Reference	Respondent	Question	Response
<b>1 - Miscellaneous and General</b>			
MG1.1.22	The Applicant Portsmouth City Council	Does Portsmouth City Council accept that it would take responsibility for the maintenance of the proposed landscape planting at the landfall after 5 years of establishment, as suggested at 1.6.4.1 of the Outline Landscape and Biodiversity Strategy [APP-506]?	<p>Portsmouth City Council (PCC) would wish to contain control of all relevant parts of our land. Whether maintenance responsibility should sensibly pass to PCC would be dependent on whether that landscaping was on land retained by PCC or on land that has passed into the applicant's control or ownership. If the proposed landscaping was on land that has passed into the applicant's ownership PCC would not expect to be burdened with the maintenance of it but would expect an appropriate requirement to approve a landscaping scheme and require the applicant to maintain it to fulfil its amenity and other purposes.</p> <p>Where landscaping is proposed on land retained by PCC the Council would accept the responsibility for maintenance after 5 years of establishment but an appropriate commuted sum to be paid by th

**AQUIND Interconnector
Hedgerow and Tree Preservation Order Plans
KEY PLAN**

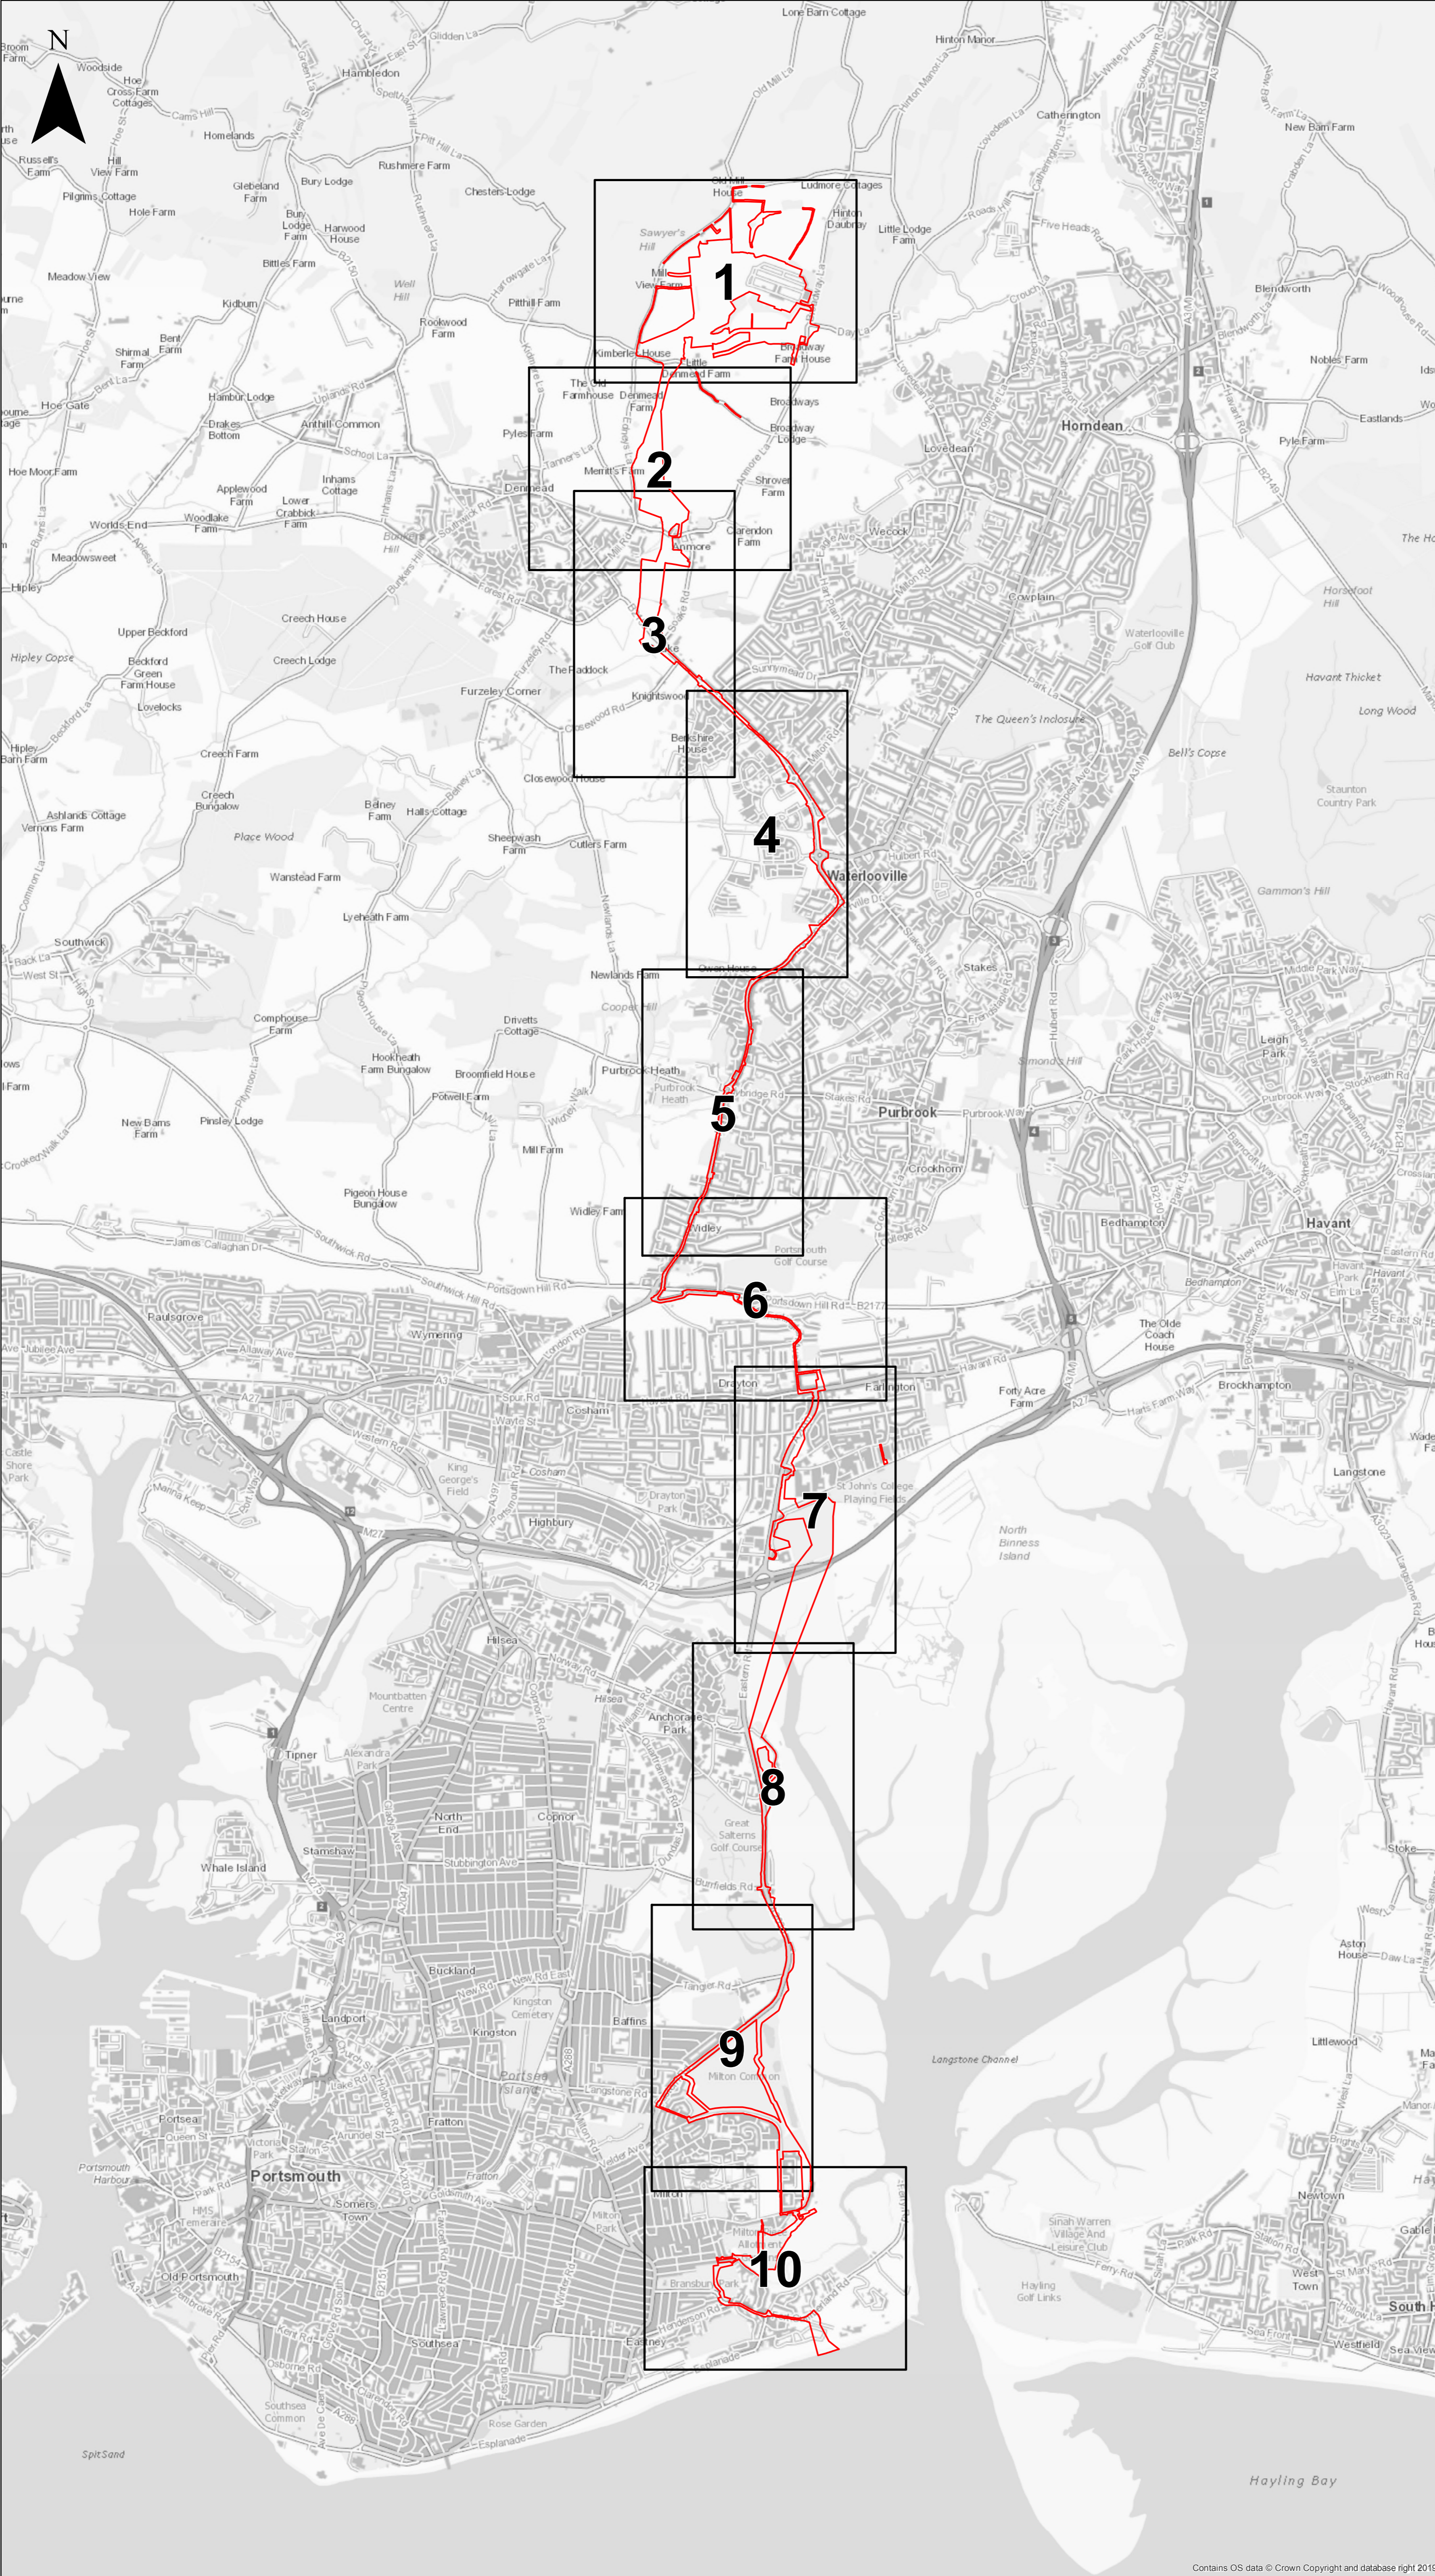
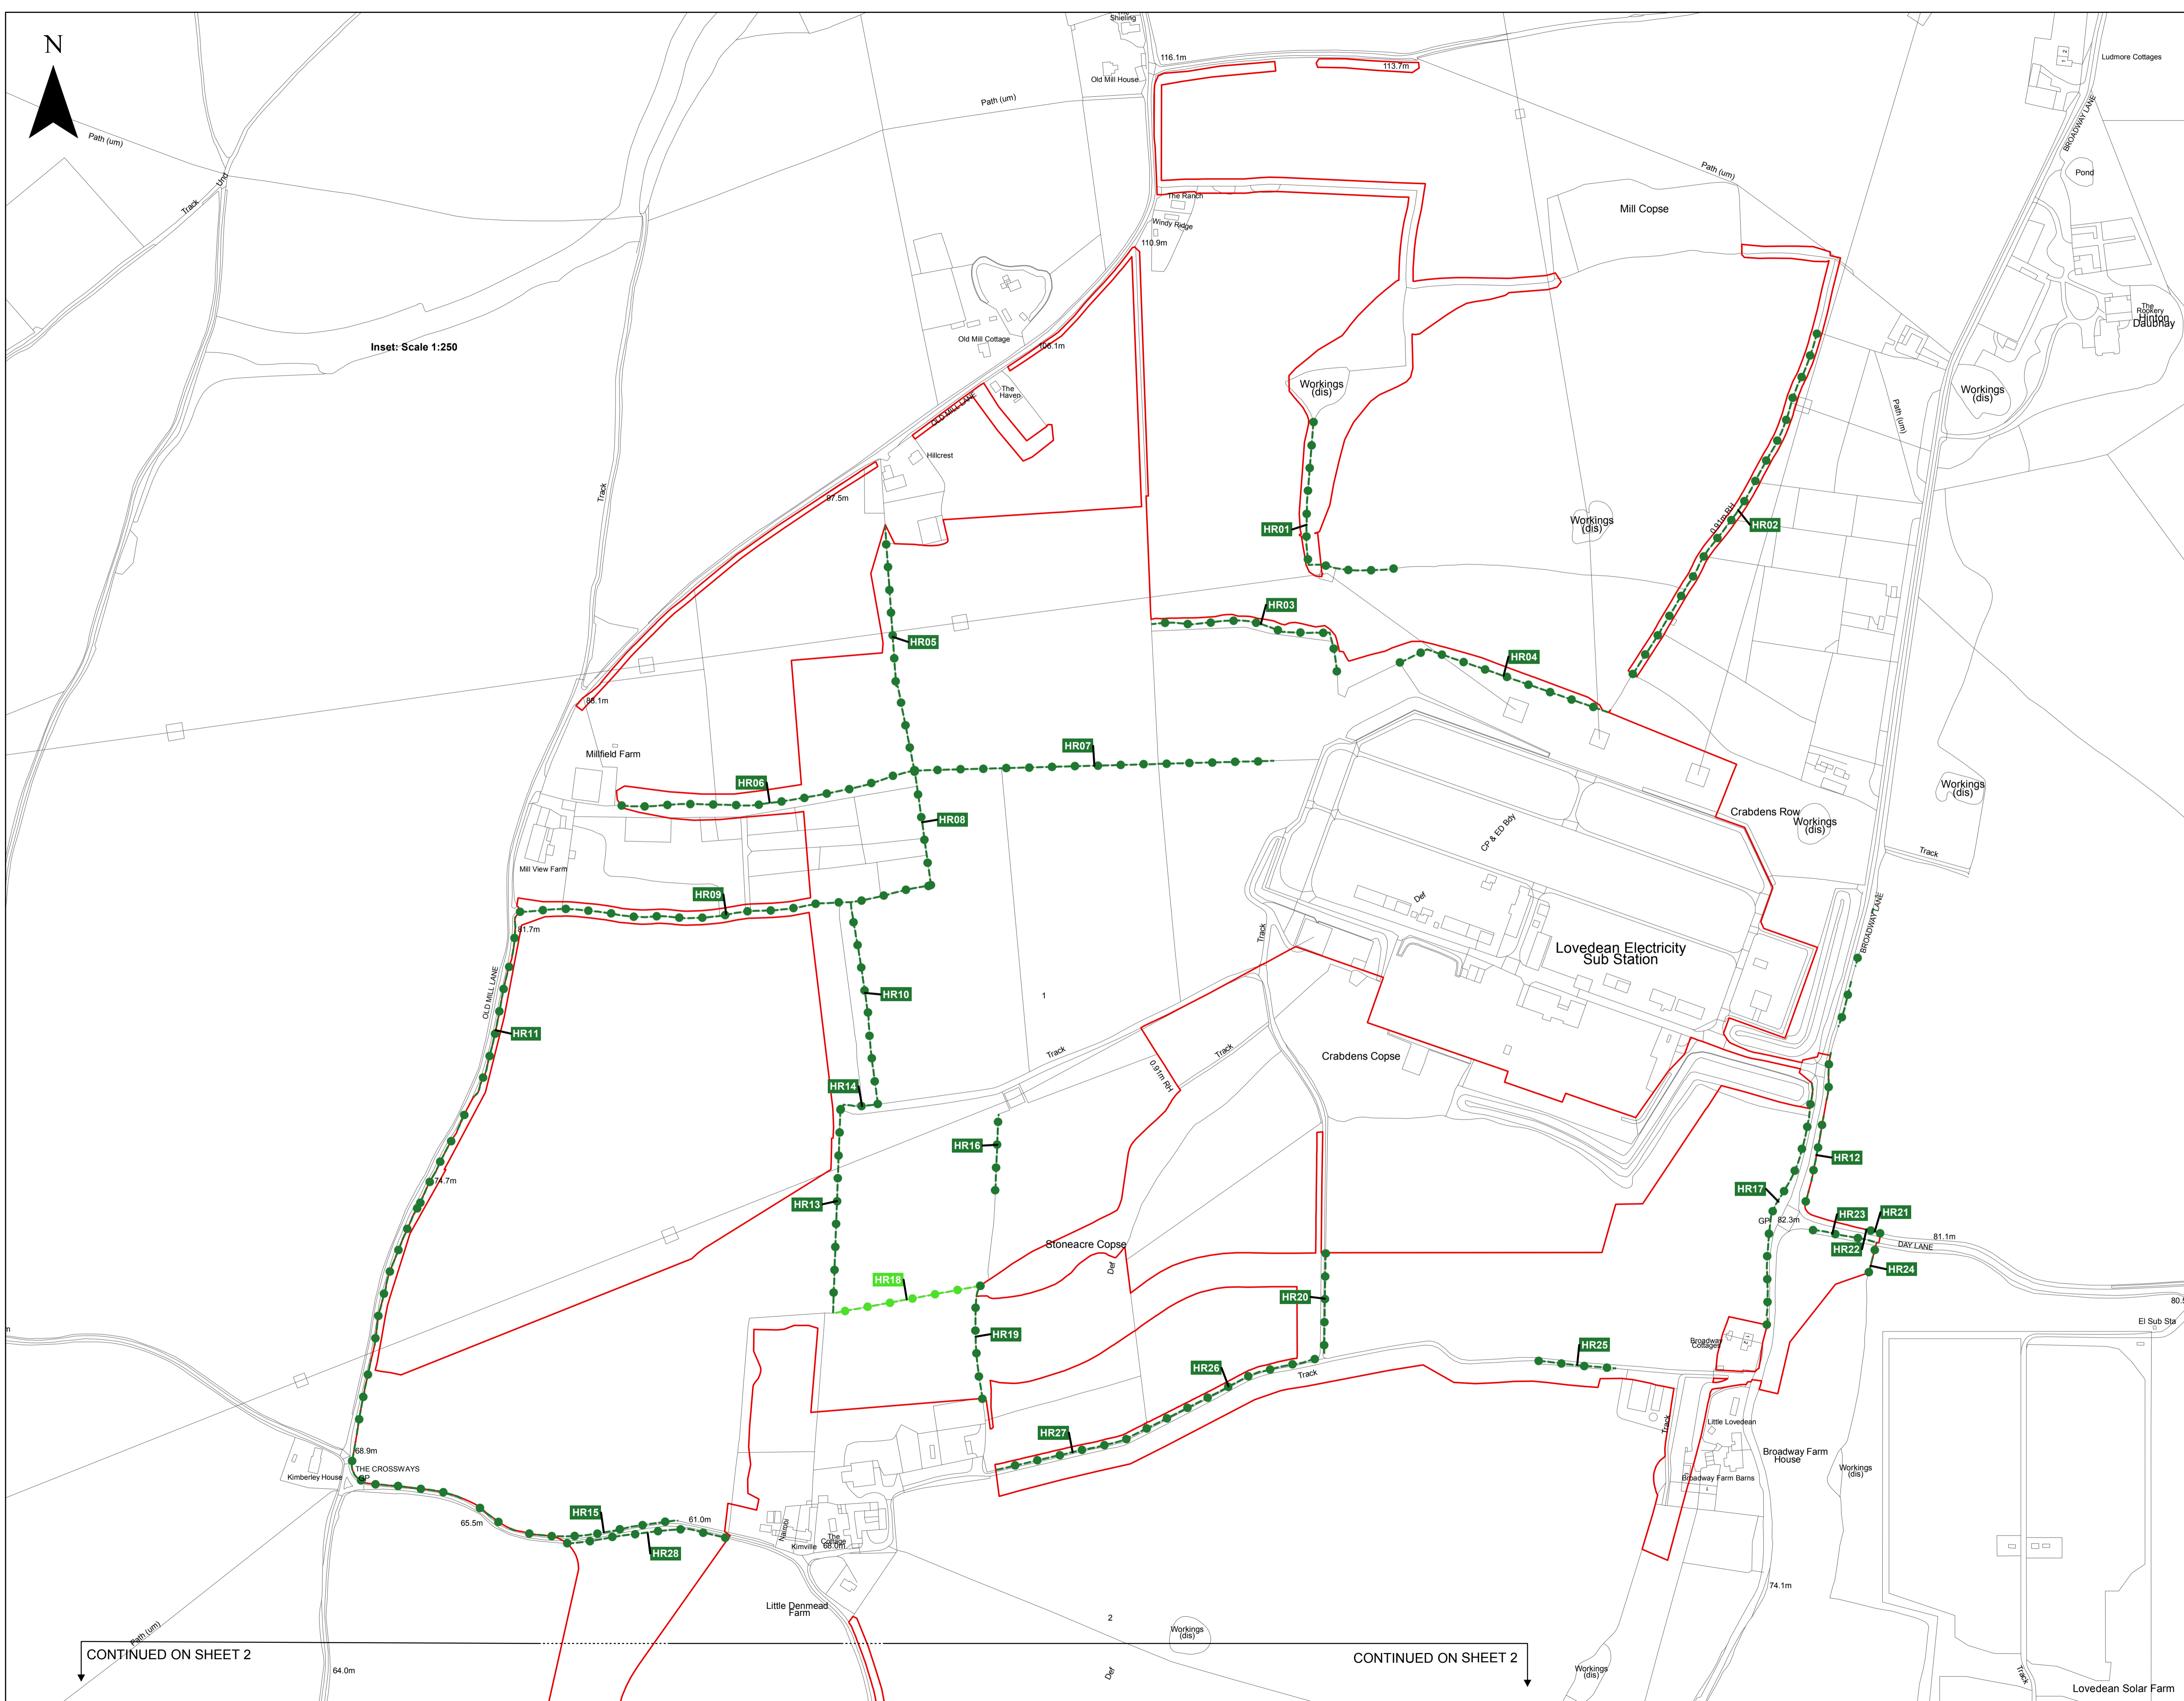
The Applicant seeks powers over any tree in the Order limits rather than providing a schedule (as per model provisions and as is usual in other recently made DCOs). Schedule 11 of the dDCO [APP-019] (TPO trees) only lists 'potential removal' and 'indicative works to be carried out'. How can this be specific enough to understand the impact of the Proposed Development on trees? If this remains unchanged, should the ExA in weighing the benefits and disbenefits of the Proposed Development therefore assume the loss all of the trees within the Order limits during construction and throughout the lifetime of the Proposed Development, given that 42(2)(b) of the dDCO [APP-018] removes any duty to replace lost trees?	<p>All trees to be impacted upon must be individually identified and work proposals specified in a detailed schedule.</p> <p>If this remains unchanged, the ExA must in weighing the benefits and disbenefits of the Proposed Development assume the loss all of the trees within the Order limits during construction and throughout the lifetime of the Proposed Development, given that the proposal at 42(2)(b) of the dDCO [APP-018] removes any duty to replace lost trees?</p> <p>The potential for unmitigated loss of amenity and eco system services provided by the city's trees is huge.</p> <p>The breadth of article 41 is unacceptable and displays a lack of understanding of how local authorities manage their trees, approaching the matter through a misguidedly legalistic lens. Even then, as highlighted, Schedule 11 only engages with TPO protected trees at a disappointingly high level. The applicant may seek to argue the need for operational flexibility justifies the "potential" removals listed in Schedule 11 or the wording of Articles 41 and 42, but without any further requirement to obtain permission it must be assumed that arts 41(1) and 42(1) will result in the felling of all trees if it is commercially expedient to the undertaker. In the case of 41(1) this would occur without obliging the applicant to have regard to the amenity or other value of any tree, no matter how mature or otherwise noteworthy.</p> <p>A phased approach (such as that seen in relation to archaeology and with particular sensitivity to site clearance works falling within Onshore Site Preparation Works) could be taken for the local planning authority to approve any felling or works to trees located on land in which PCC has a legal interest, and confirm precisely which trees are not intended to be felled or subject to works. Further approval from the local planning authority should be sought to confirm that other such trees shall not be felled or worked upon (without any deeming provisions) following commencement. Such approvals for non-TPO trees should empower the local planning authority to be able to enforce appropriate replacement trees.</p>

Reference	Respondent	Question	Response
			<p>Given the requested exemption from re-planting obligations, the oversight of the local planning authority is especially important to ensure that the undertaker is accountable for its actions in relation to trees. The apparent disregard for trees as protected public assets gives PCC serious concern about whether they retain the relevant technical skills and understanding of balancing the public interest to make appropriate decisions about works to trees. The undertaker's powers should be curtailed in relation to trees and subject to local planning authority approval in relation to all trees on land in which PCC has a legal interest. It is noted that the Thanet DCO, Article 34, only granted the undertaker the power to fell or lop only those trees made subject to a TPO after July 2017, being a year before the application was accepted for examination.</p>
